Re: Planning Application 2026/0713

Demolition of existing dwelling and associated outbuildings, with erection of 4no. detached dwellings and garaging; Stone Croft, 1 Hall Royd Lane, Silkstone Common, Barnsley, S75 4PP

The Coal Authority response: **Fundamental Concern**

5.2 Borehole/Probe-hole Location Plan No. 00391/B

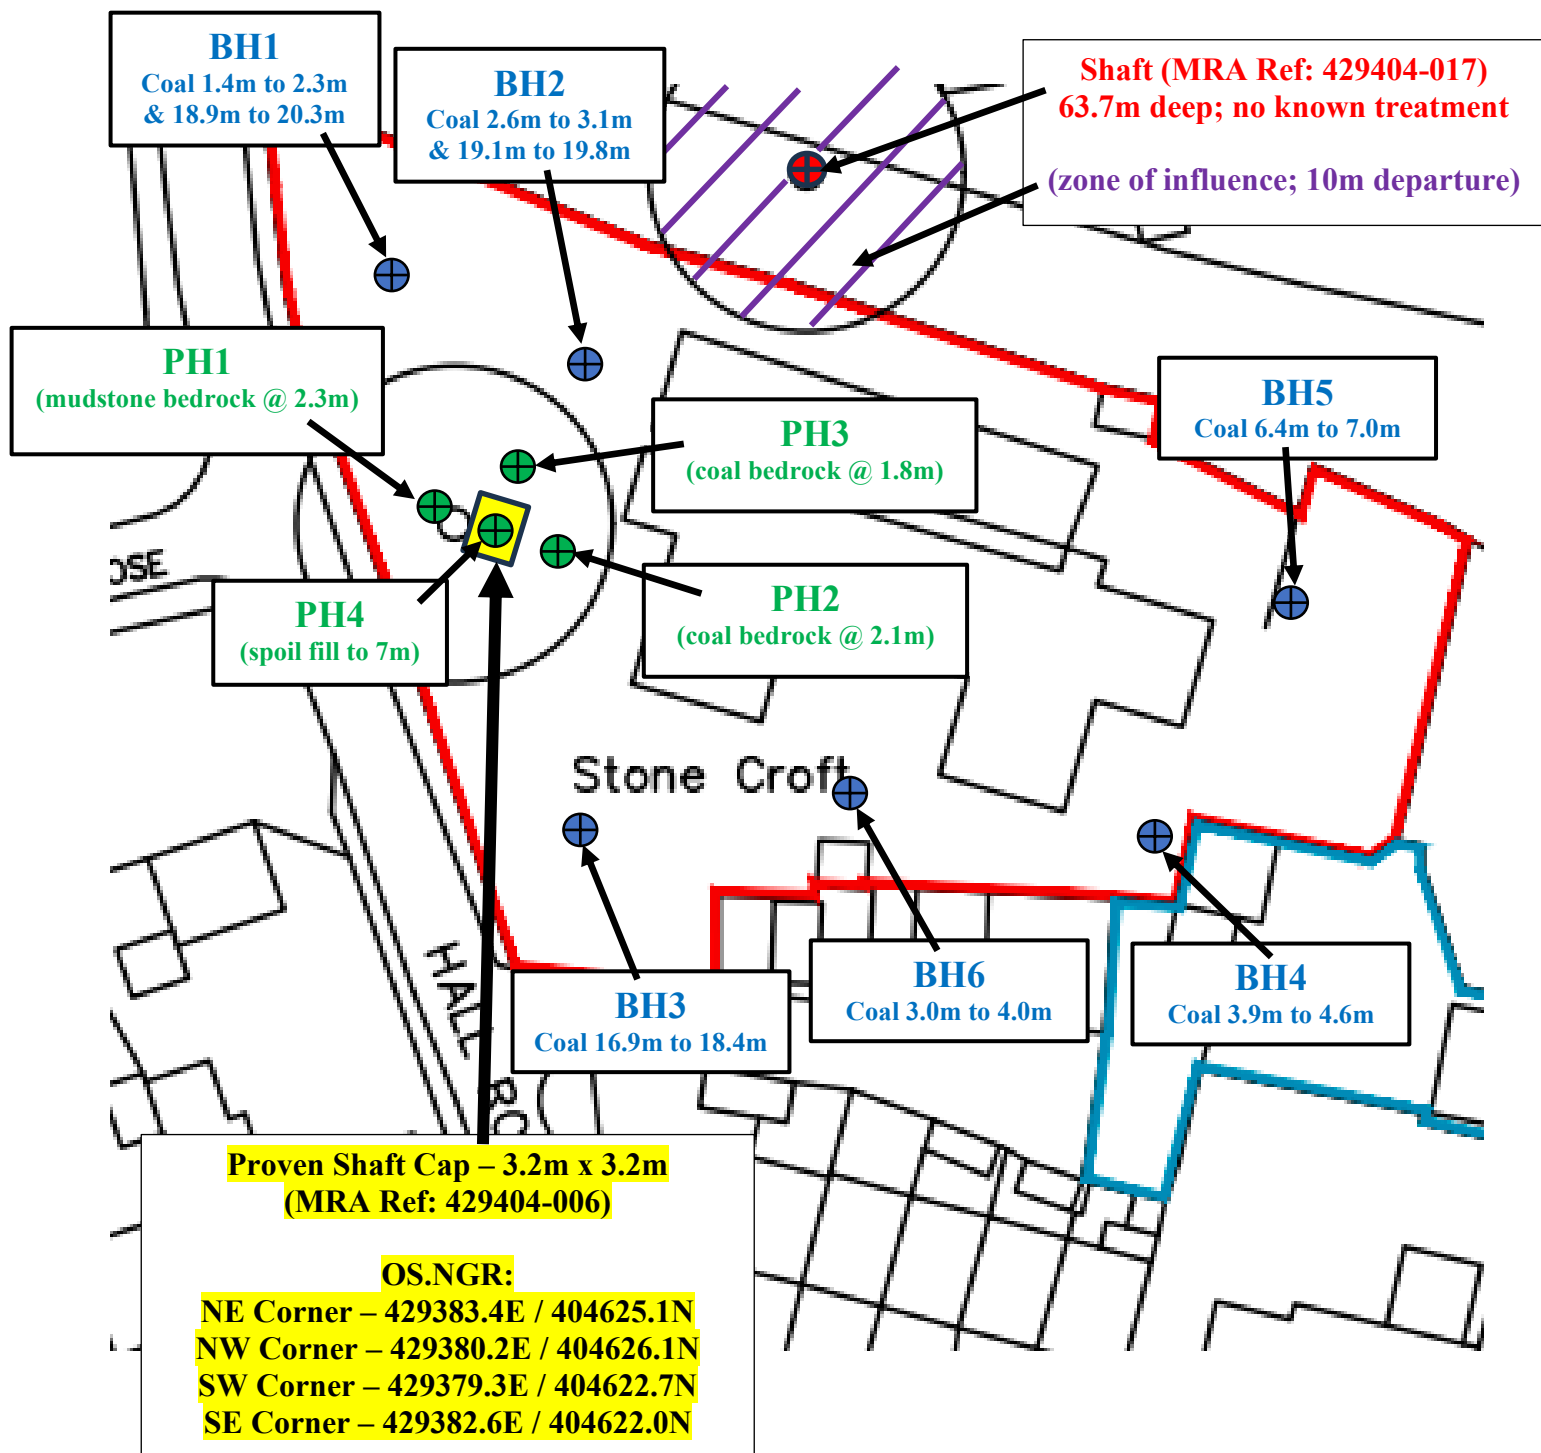
The report author notes that the probe hole investigations have proved the location and treatment of shaft 429404-006 and recommended that any proposed building foundation should be sited clear of the cap by at least 3m. The report author outlines that *"as the shaft has been proved to be filled, it may be acceptable for soft landscaping (gardens for example) to be maintained (like present) as the use above the cap itself; any other uses, such as hard standings/driveways, over or in close proximity (within 3m), will require the prior design approval from the Mining Remediation Authority."*

Furthermore, the author notes that *"development should be avoided from the small area of the 'zone of influence' of the adjacent mine shaft ref: 429404-017 to the north of the site, as outlined in the attached plan – which equates to a 10m radius (MRA 'departure') drawn from the*

plotted shaft position. This situation could change however, subject to a further site investigation (following site clearance), that 'disproves' the mine shaft within the site itself to the boundary line in that zone. If this is determined, then building foundations should be sited away from the boundary line by the same distance to bedrock/formation level (to achieve the 45 rule should the shaft be present directly adjacent the site boundary to the north)."

As such, the Coal Authority considers that site investigations designed and carried out by competent persons should be undertaken prior to determination of the planning application in order to locate outstanding mine shaft 429404-017 across the departure area that falls within the application site. We acknowledge that there may be scope to carry out an additional search for this shaft in the area under the applicant's ownership.

We would request that the applicant and their technical consultant to incorporate the results of these investigations into a revised report. This should take account of the mine shafts departures (potential plotting error) and local ground conditions as identified by intrusive investigations on site and define appropriate 'no-build' zones around these features. An amended site layout drawing should then be provided which demonstrates how development is to be arranged on site in a manner which avoids the defined 'no-build' zones.
